Subject: Objection to proposed 40 houses – planning application Y/93/14/OUT

Reference: Y/93/14/OUT - Land North of Yapton C of E Primary School North End Road Yapton BN18 0DU

DRAWING NO YAP/DR/1

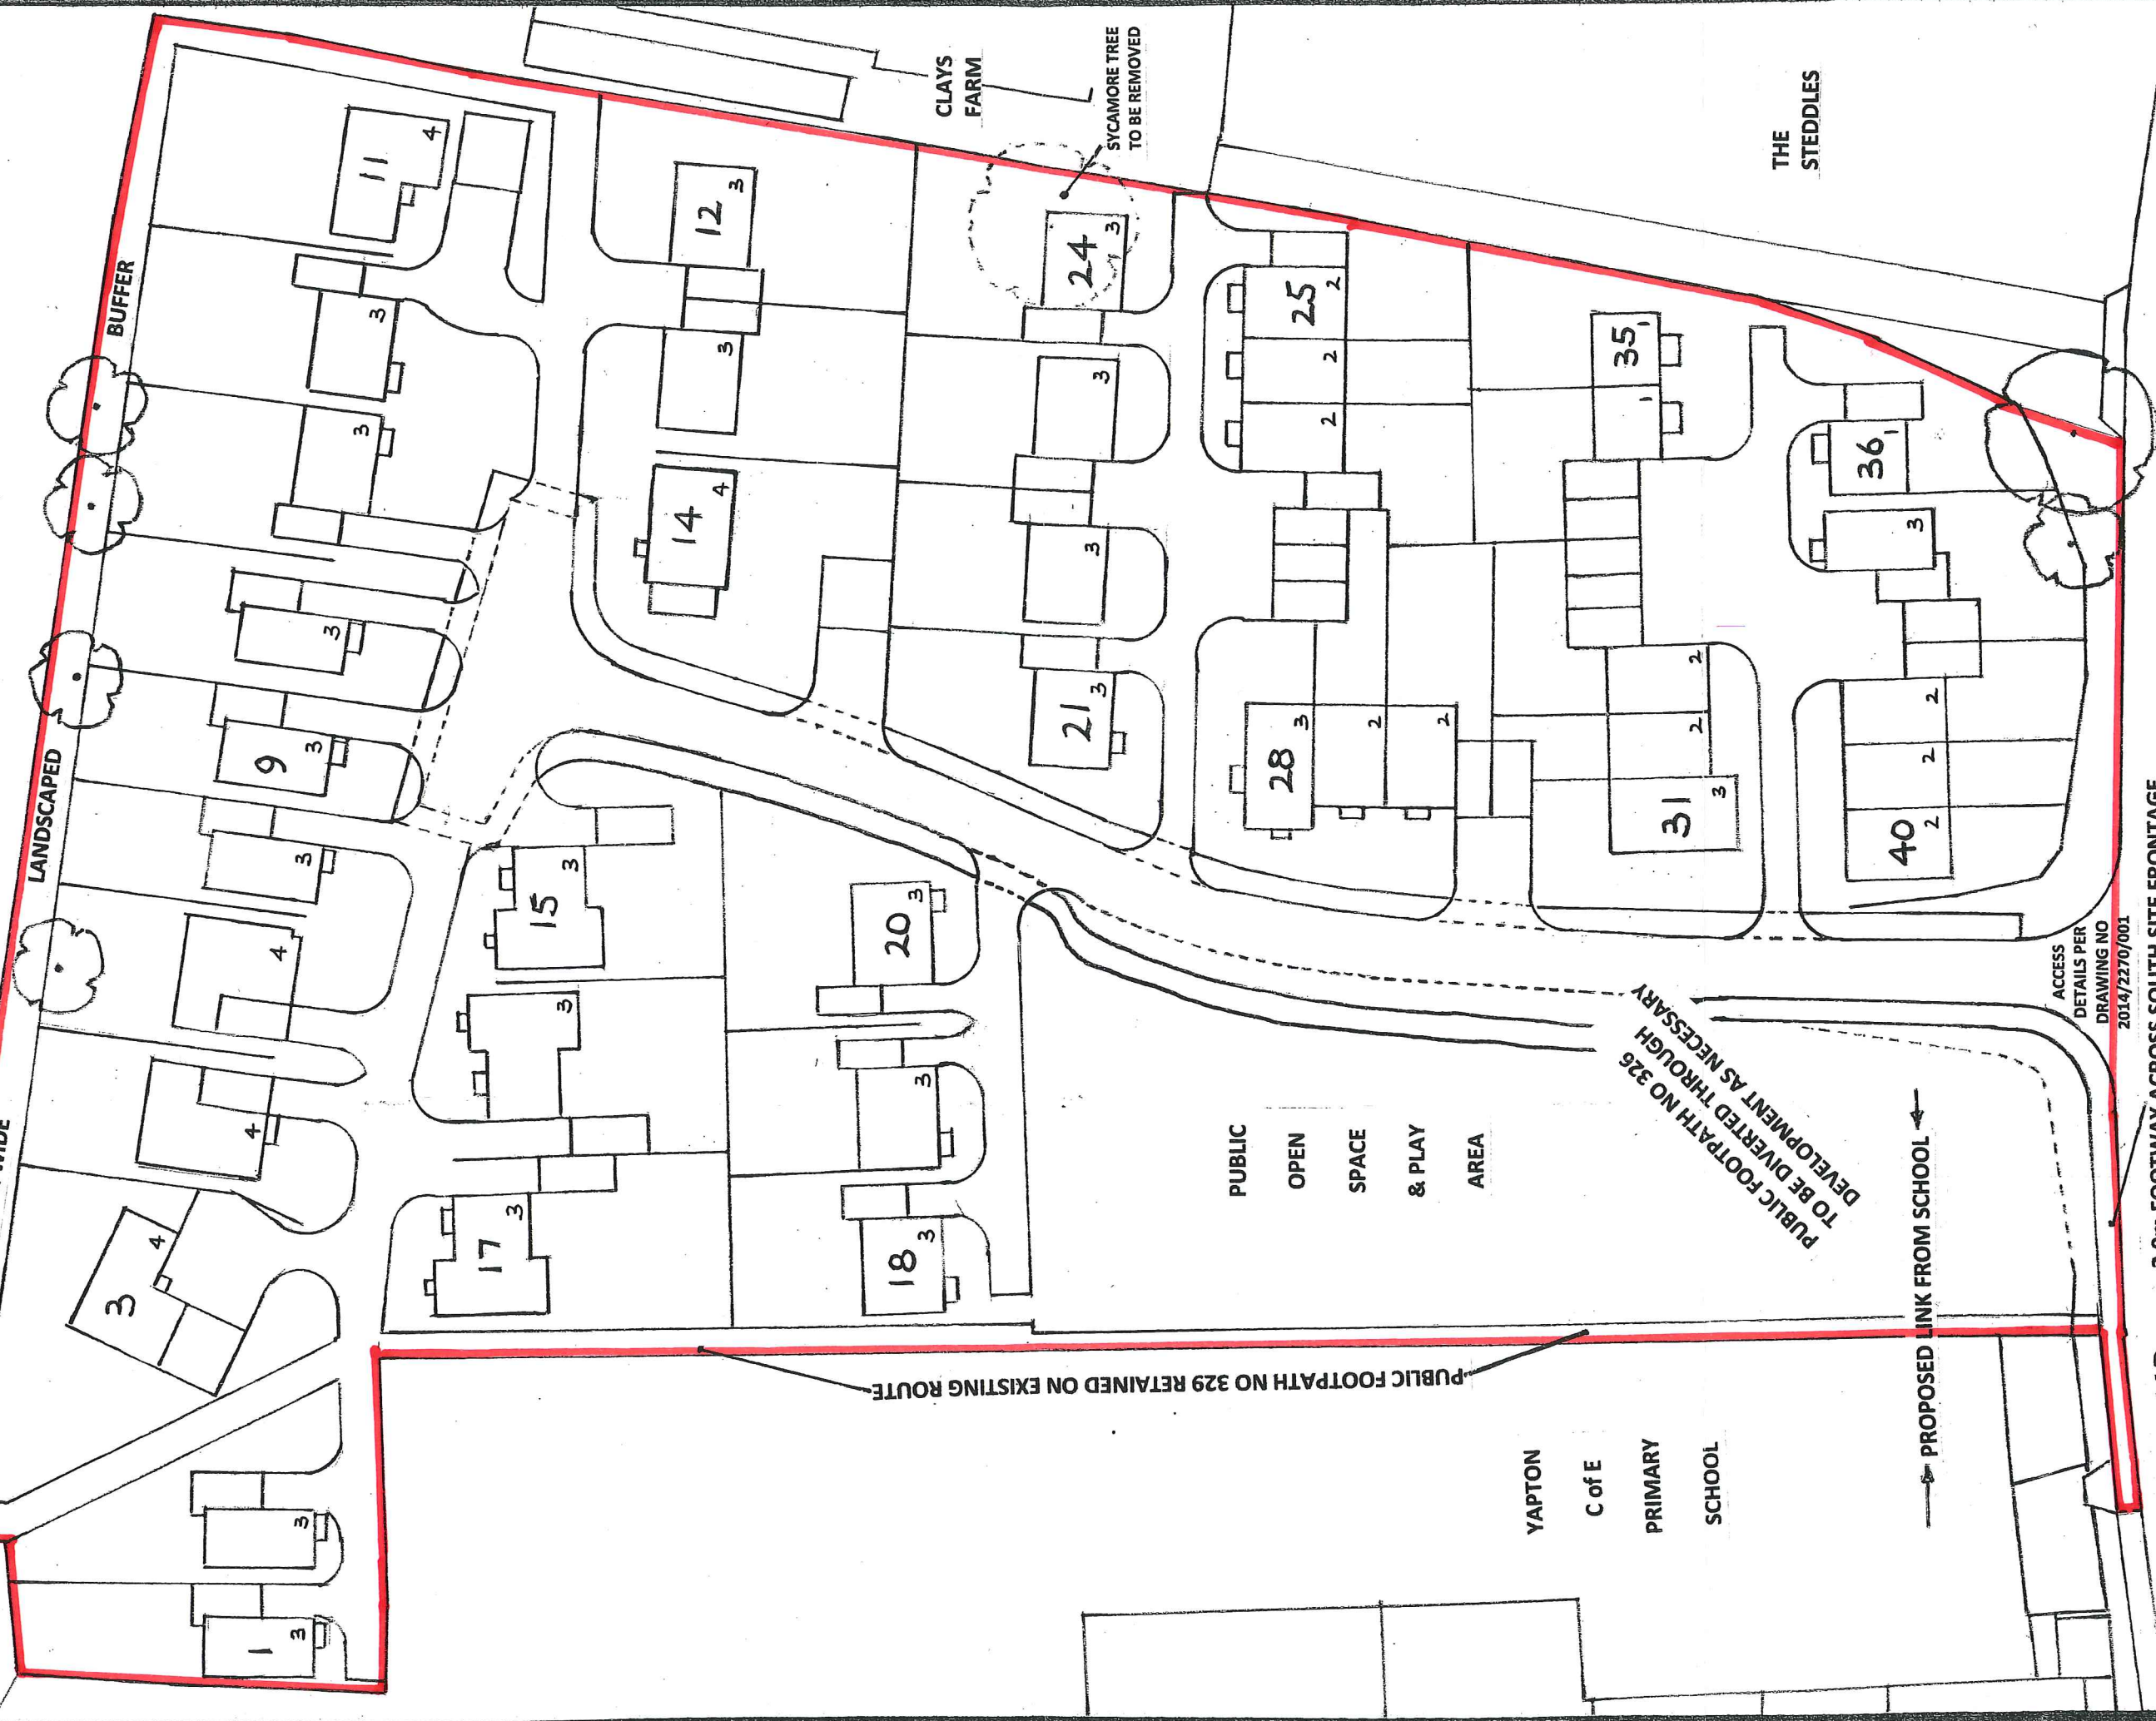
2) The proposal refers to 40 parking spaces based on 1 car per household although:

bedroom homes). In excess of 40 cars cannot be accommodated on the proposed site which will mean spill over on to North End Road which is already heavily congested during school pick up / drop off times.

3) The planning proposal suggests a "proposed link with school" may be considered - I note that this link is being proffered from the green space ie reduced green space and a "break" in the public footpath - is this correct? The green space is already limited in size for a development of this scale.
